Subject: RE: Further consultation on planning application 3/2018/0361 Former Victoria Mill,

Watt Street, Sabden BB7 9ED

Having reviewed the amended FRA, I have been unable to find anything that sufficiently addresses the concerns raised in the second point of my original response (dated 4 June 2018). This relates to a lack of evidence to show how the applicant has estimated the existing surface water runoff rates for the previously developed site. Please can you arrange for this necessary evidence to be provided so that I can complete my assessment of the development proposals, and so that I can provide you with a substantive response. If this cannot be achieved, then please let me know and I will consider whether a formal objection is required from the Lead Local Flood Authority.

EXISTING IMPERMEABLE AREA PLAN

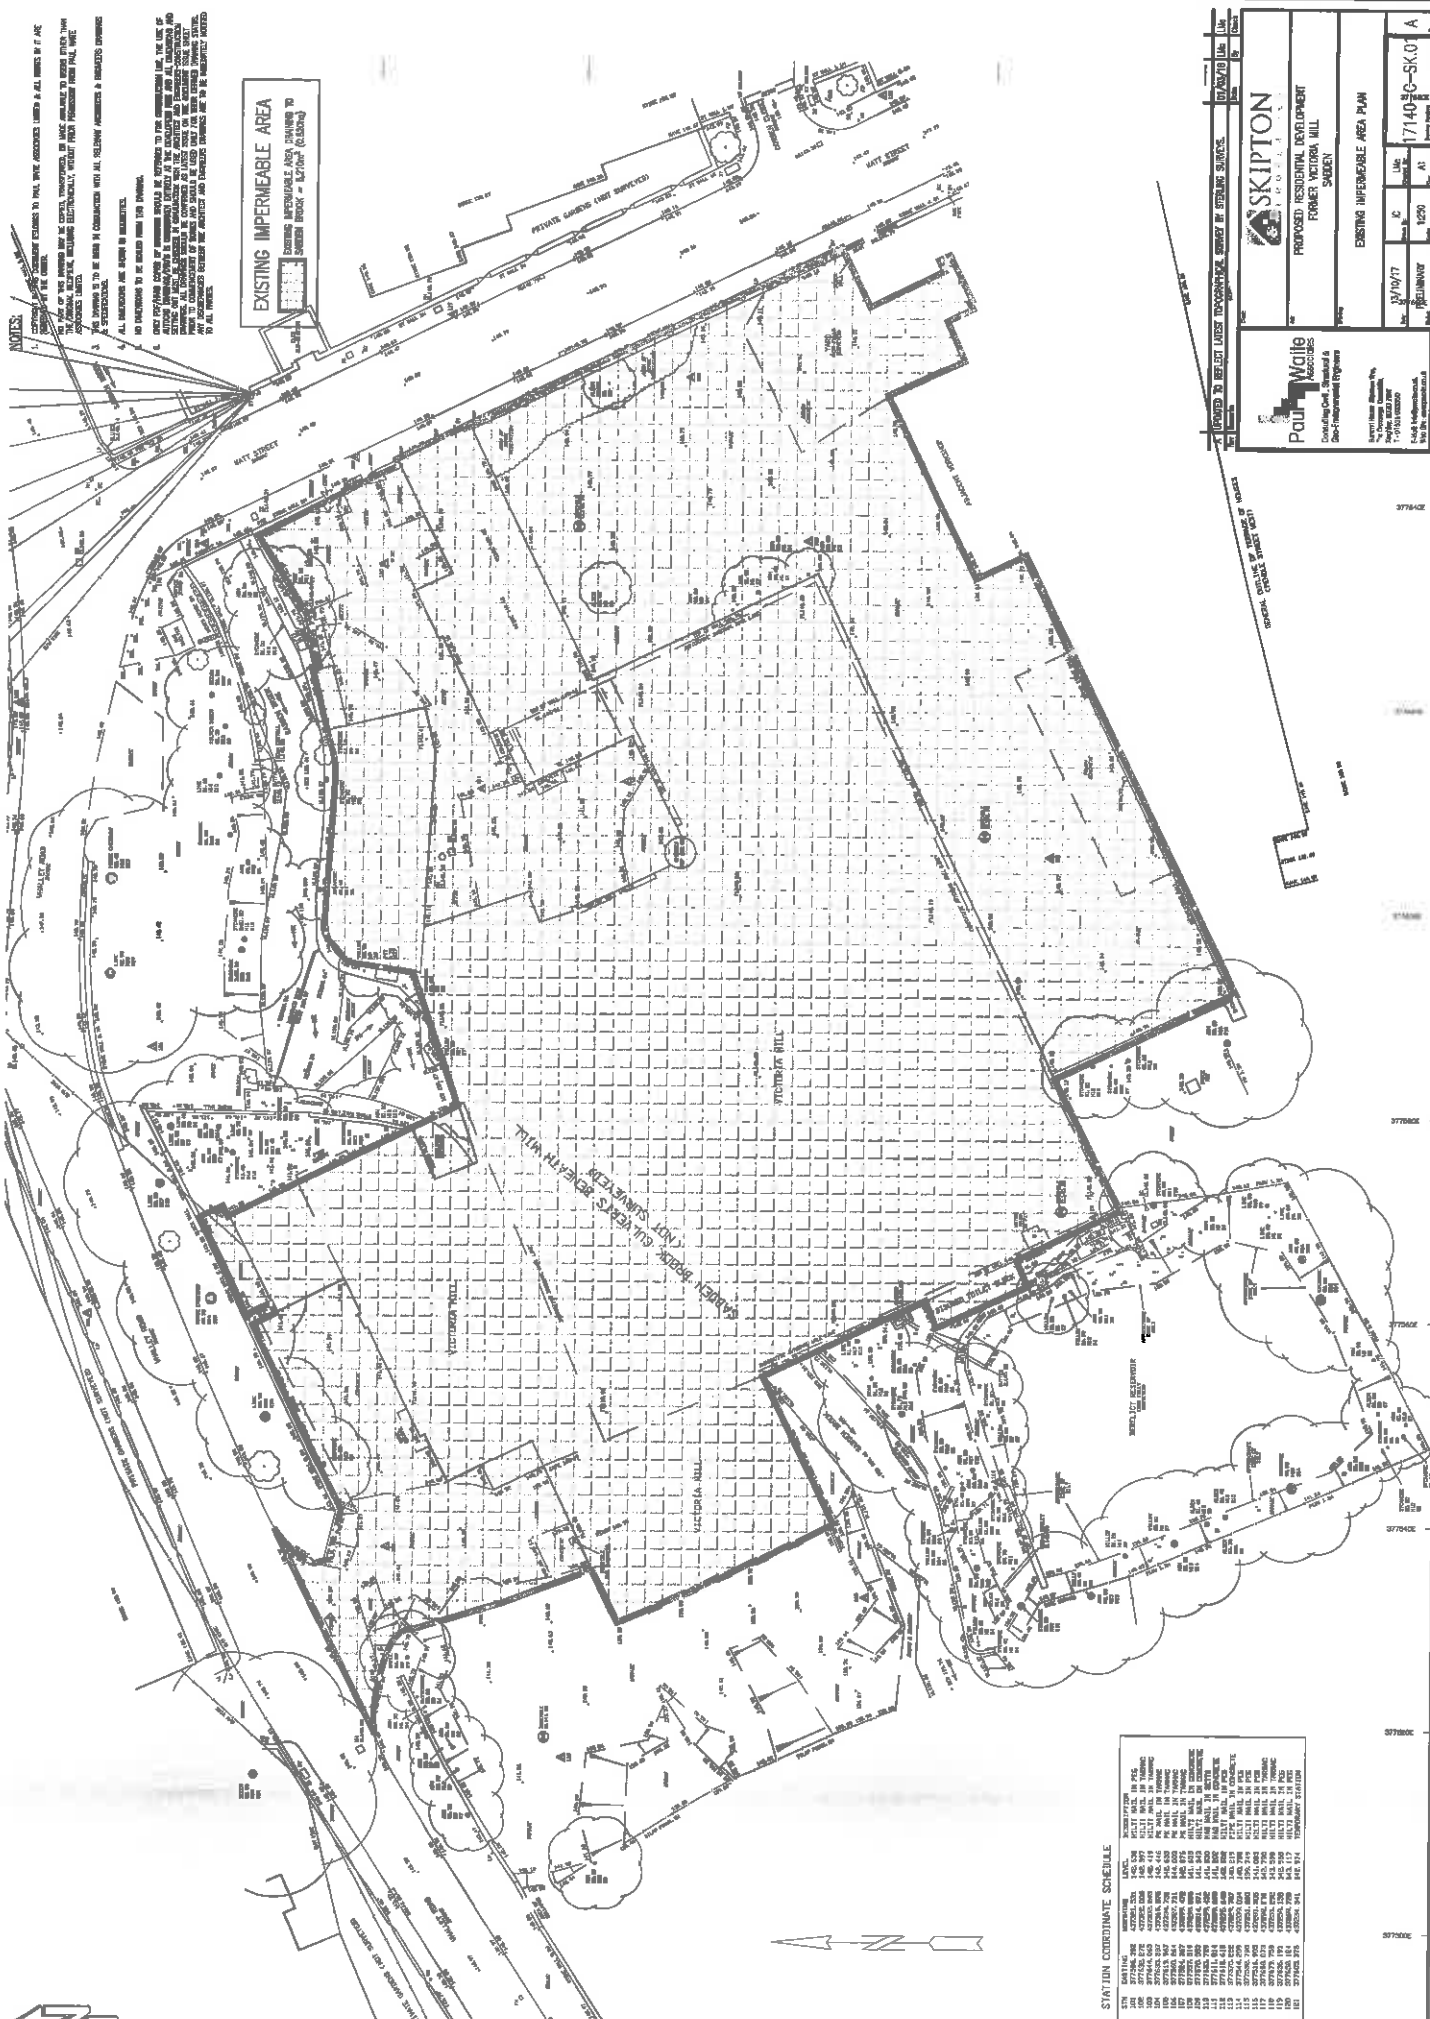
For clarity, the applicant is expected to demonstrate that the existing surface water runoff rates have been estimated in accordance with the methodology outlined in Section 24.5 of the CIRIA SuDS Manual 2015. In order to do this, the applicant will need to demonstrate that they have properly investigated and simulated the existing surface water drainage network; deriving a head-discharge relationship at the outfall. This can be demonstrated by submitting a CCTV survey and drainage layout plan for the existing surface water drainage network, together with supporting calculations showing the design criteria and simulated outputs for the existing drainage network. The simulated outputs should cover the 1 in 1, 1 in 30 and 1 in 100 year events.
